Change of use of houses in multiple occupation (Sui Generis) to create 2 No 1 bed, 2 No 2 bed self contained flats & single storey rear extension to form 2 No studio flats (C3 Dwelling House).

34 & 36 Southdown Road Bognor Regis

Thank you for your internet representation made on 19th November 2019 which has been recorded as '**an objection**' with the comments as follows:

Roof plan as Proposed
+ Site Layout

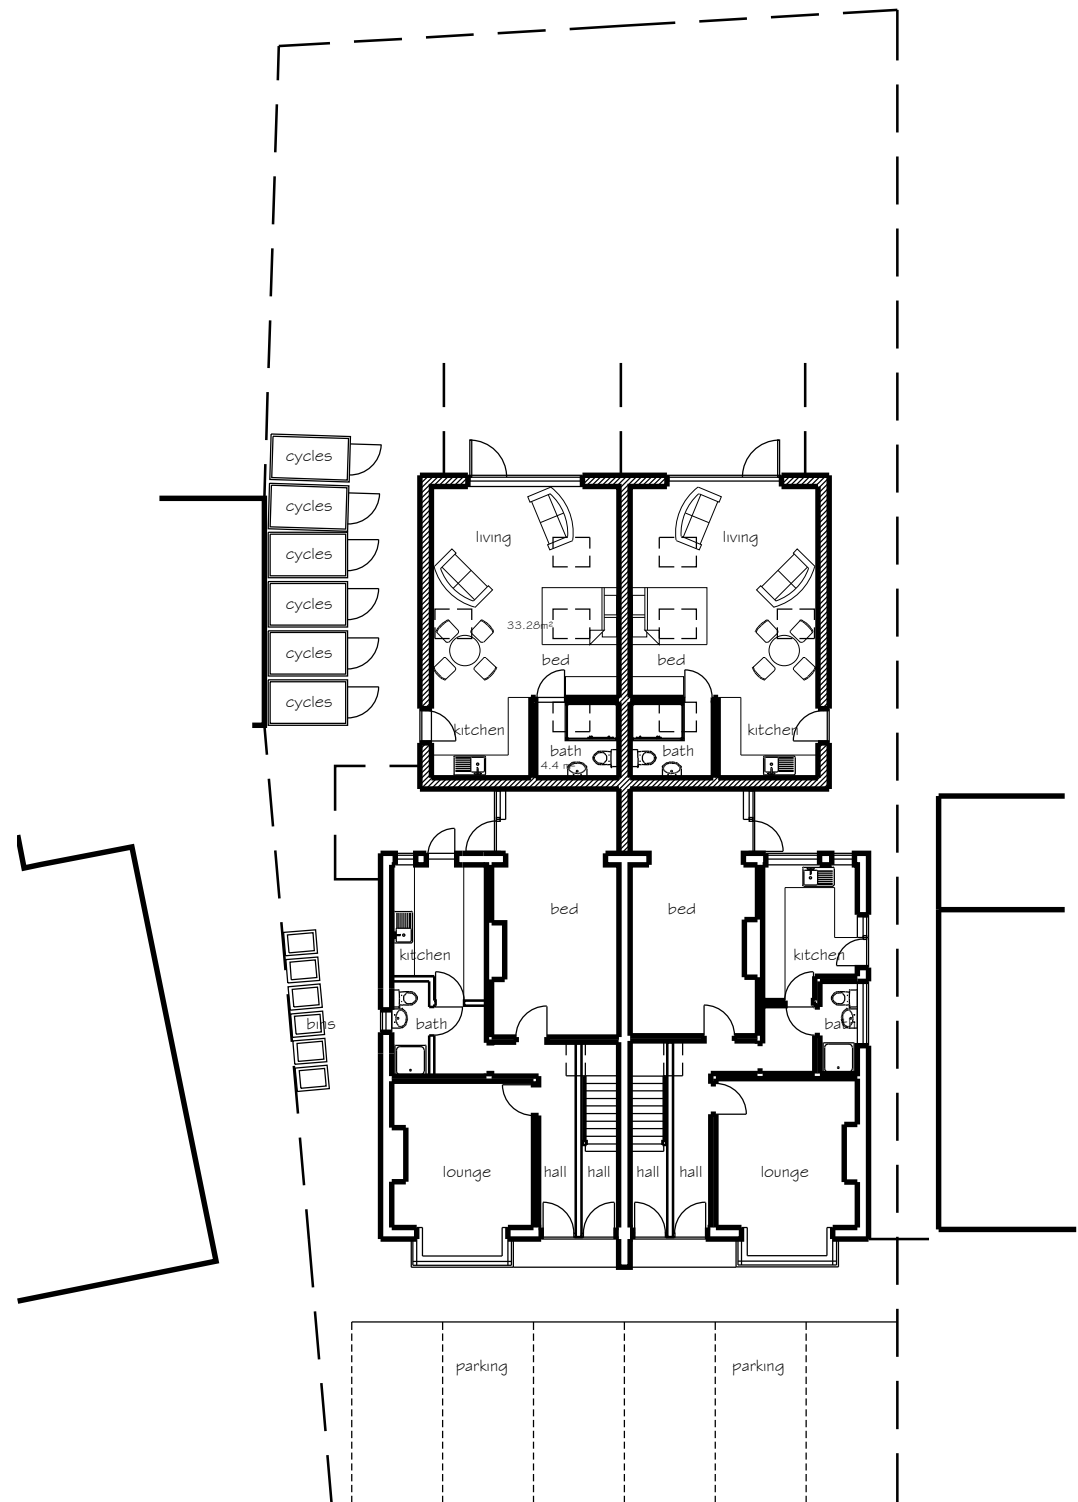
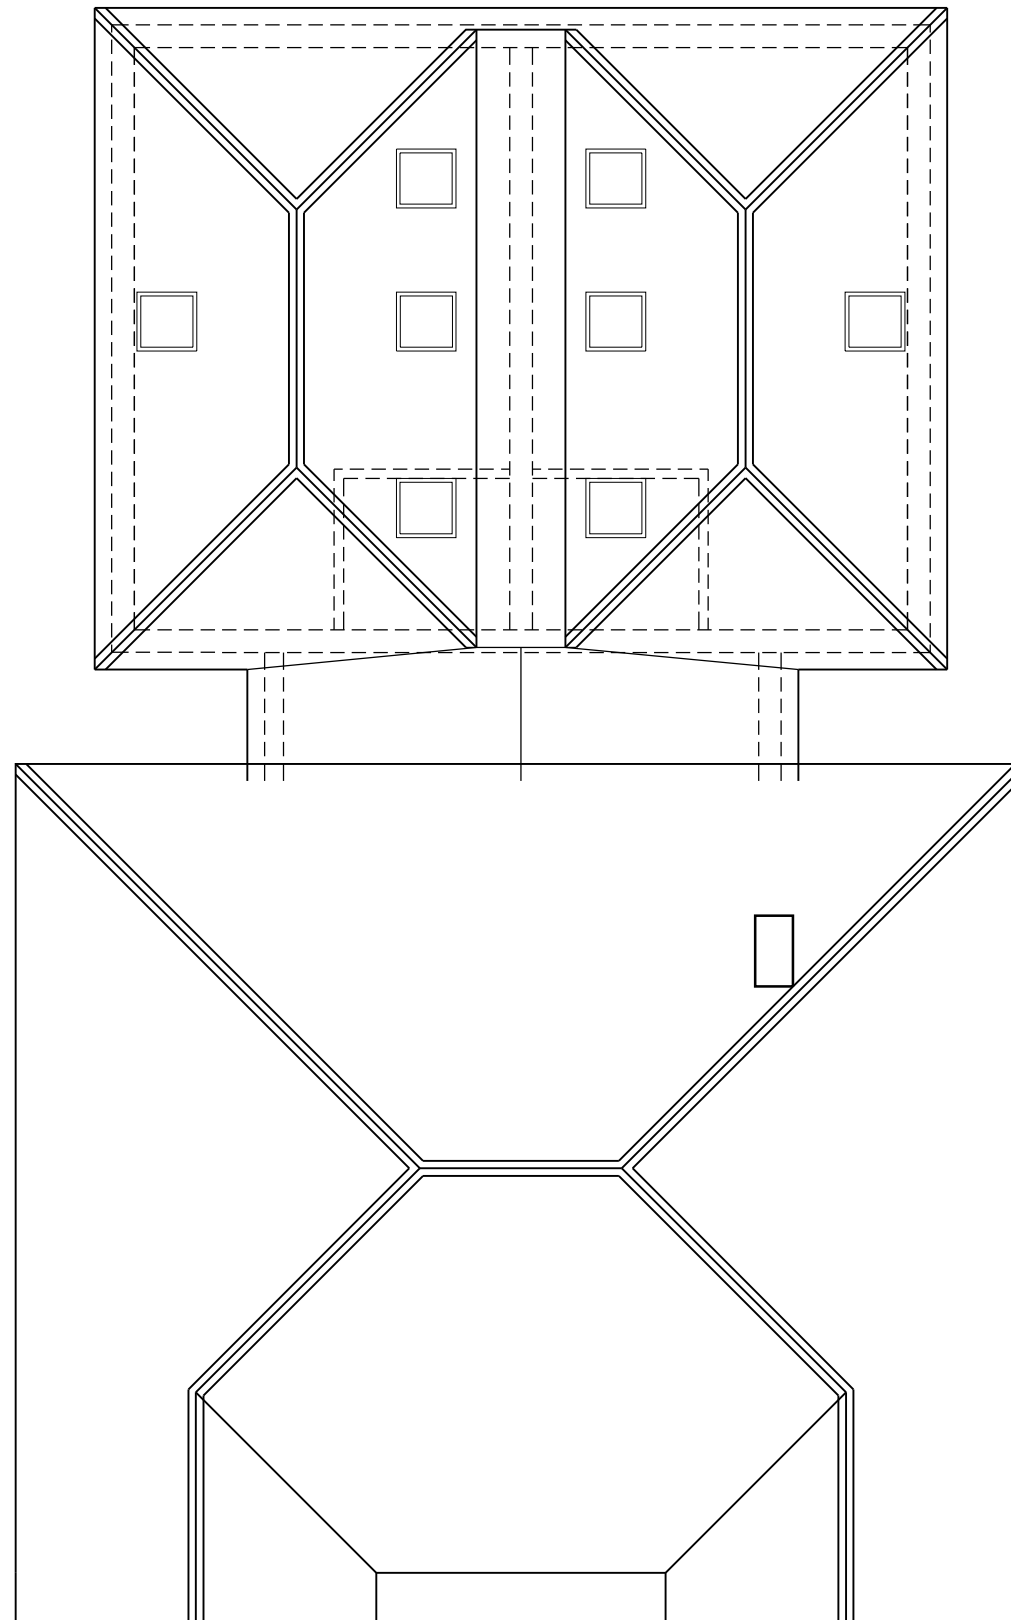
- 1. The proposed studio dwellings do not fit into the neighbourhood back garden landscape.*
- 2. The view from my kitchen window would be obstructed by the proposed roof design.*
- 3. Assuming the dividing line in the concrete, which runs the length of access to the rear of 38 and 36 Southdown Road is the boundary. My garage is built/erected 13 cm away from the boundary line. It is purposed cycle sheds are to be erected against my garage wall which is not acceptable. As the situation is at the moment the existing garage on 36 Southdown Road and mine there is a 64cm gap. This gap gives access to the 4th side of my garage for any maintenance issues and gutter clearance.*
